From: Laura Gibbons
Sent: 30 January 2019 10:46
To: Planning.Responses
Cc: Andrew Wood
Subject: RE: Planning Consultation on: FG/220/18/PL

Engineers Comments Regarding Flood Risk and Surface Water Drainage
Based on the information supplied to date we object to this application.

Site Address: Land adjacent to Elm Lodge Tamarisk Way Ferring BN12 5ER

Description of Works: Erection 1 No. dwelling with integral garage.

EXISTING POND ACCESS
PLAN

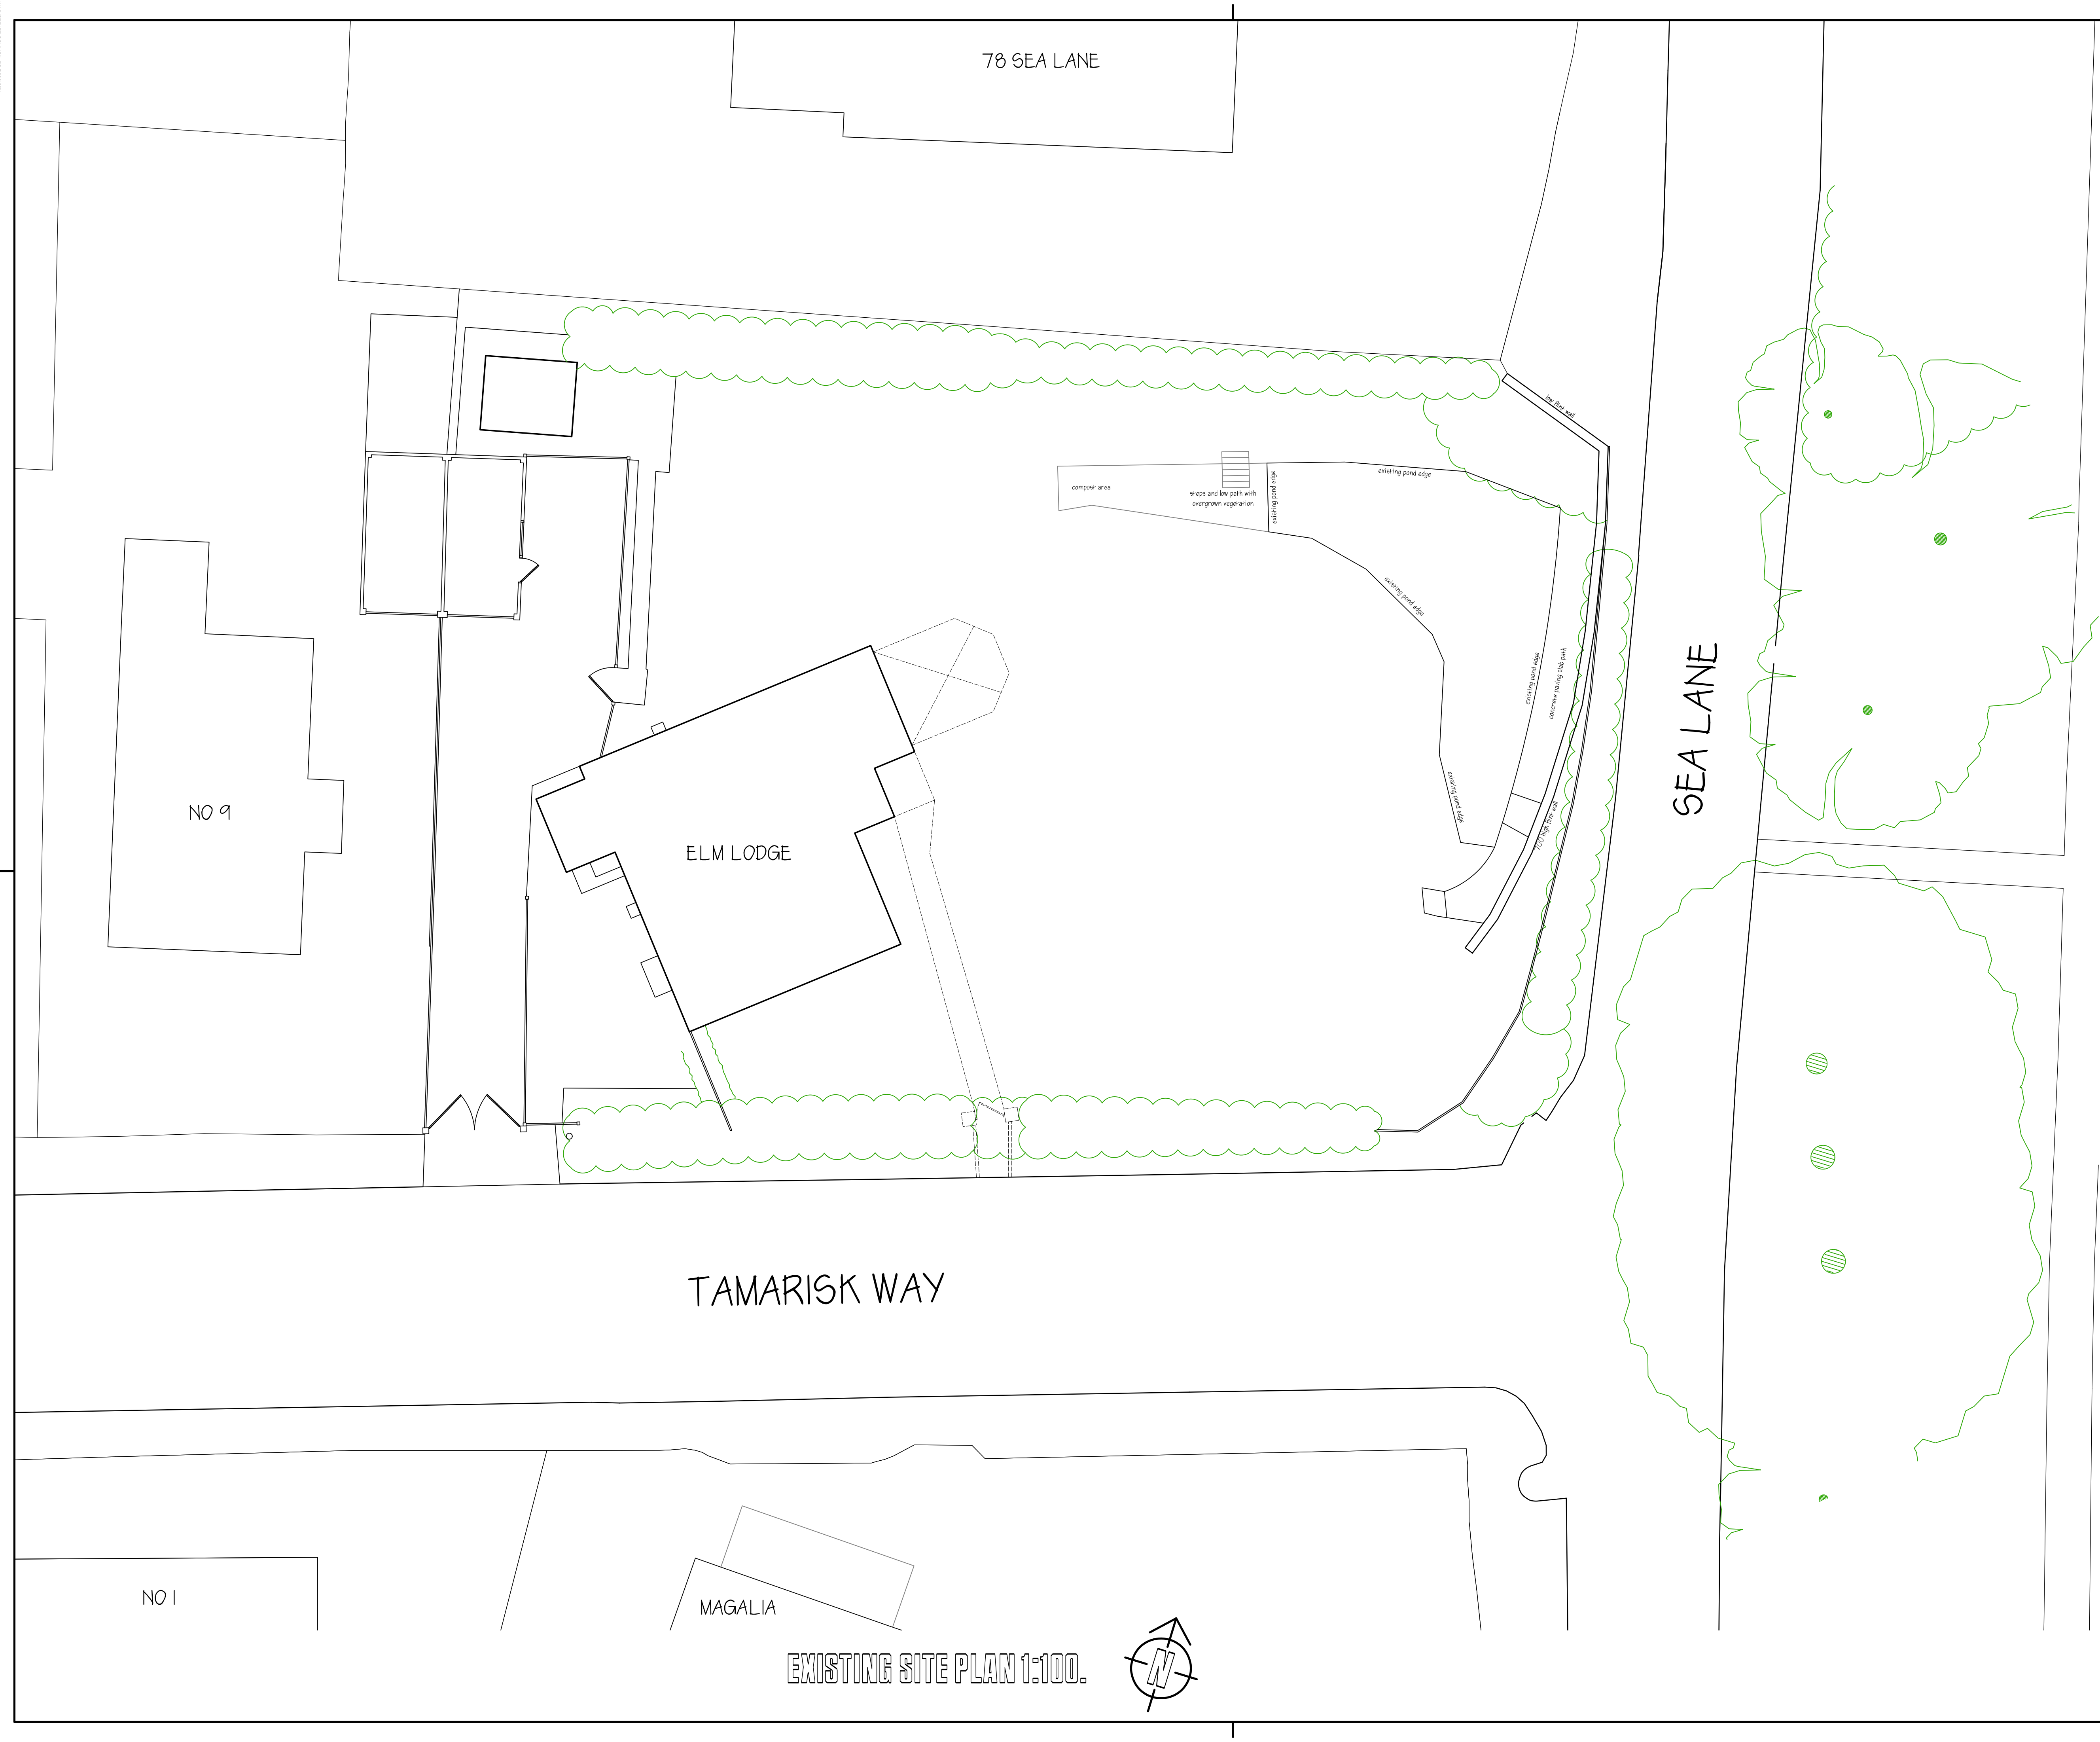
We believe the pond which is currently within the garden of Elm Lodge is interconnected to the Land Drainage system. There is a ditch network one side, and a culverted network to the other. Previous investigations identified that water in Sark Gardens drains into the pond. Historic flooding has occurred within Sark Gardens, the pond itself is also at high risk of surface water flooding.

Any proposals to alter the pond or infill it will likely disconnect the land drainage system (contrary to the Land Drainage Act 1991) and would likely increase flood risk elsewhere. The likely increase in flood risk is threefold; lack of connectivity, lack of capacity resulting in surface water being displaced elsewhere, increase in surface water runoff as a result of the proposed impermeable areas.

Drawing Title
PROPOSED LOCAL AREA
PLAN

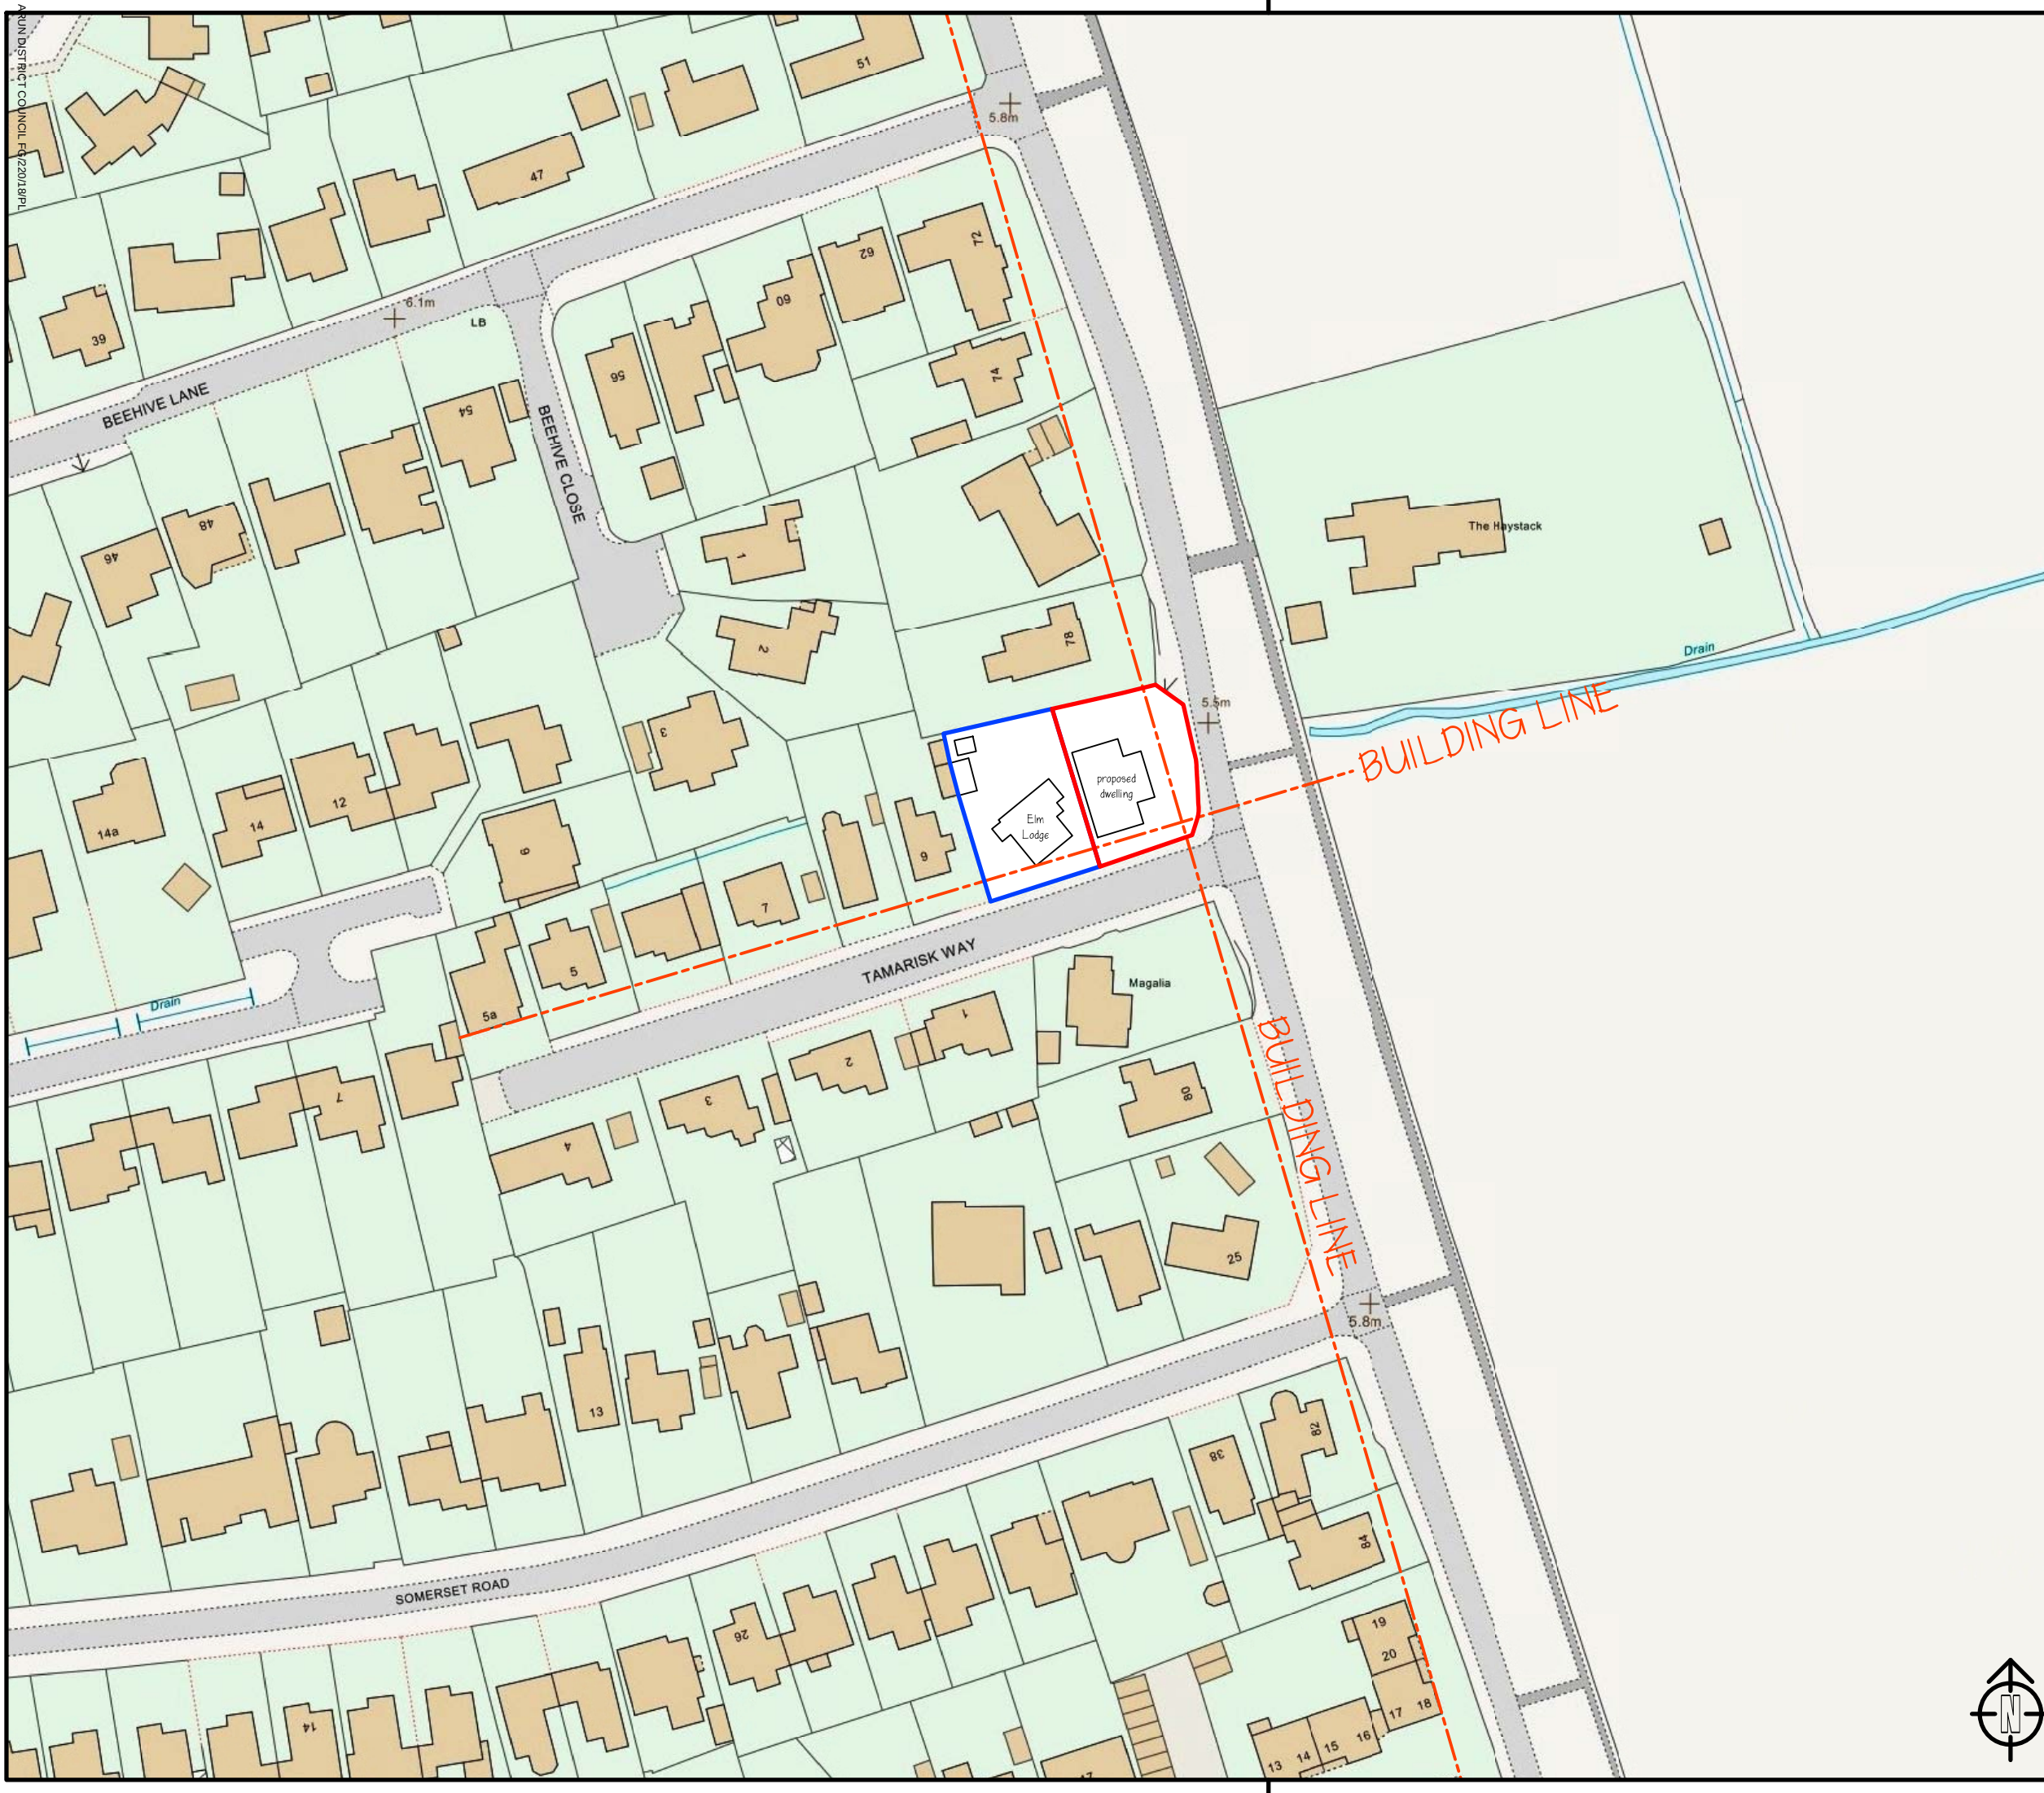
The proposal is to "reshape the pond" and construct a property at its location. From comparing proposed block plans to our mapping it looks like the property will be located in the immediate vicinity of the pond, with encroachment into it, and significant works around it. Insufficient easement is achievable to the pond with the layout as proposed. There is also limited space for surface water drainage features to be implemented to ensure surface water discharge is not increased.
